Re: Serenity Lot #903
A670 Madison model
Lateral Wall Bracing

I have reviewed the roof framing plan, Sheet S-3, of Serenity Lot #903, an A670 Madison model. Per your description provided, your framers are unable to install the (2) 48" continuously sheathed wood structural panels (CS-WSP) along the exterior face of the *Owner's Retreat* front wall.

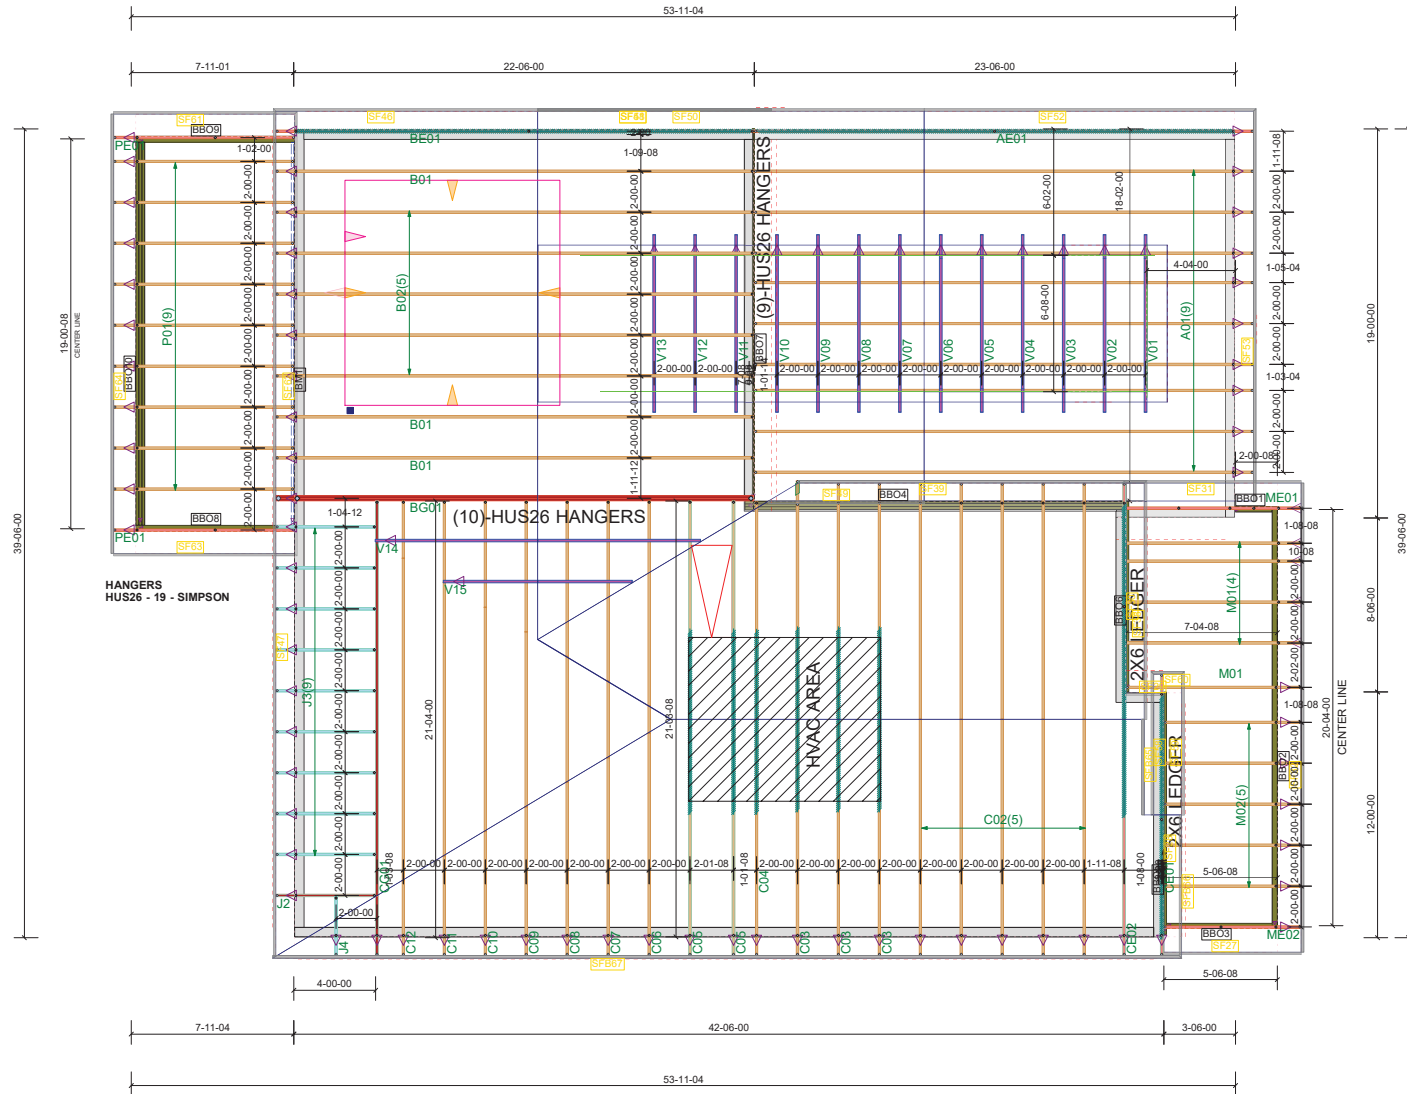
I have re-designed the wall bracing per the 2018 International Residential Code at this location.

Provided that the interior face of the *Owner's Retreat* front wall is fully sheathed with 1/2" minimum of gypsum board, fastened per panel type GB(1) of the Braced Wall Panel and Engineered Shear Wall Schedule on Sheet SD-3, the lateral wall bracing code requirements are met, and no remedial action is required.
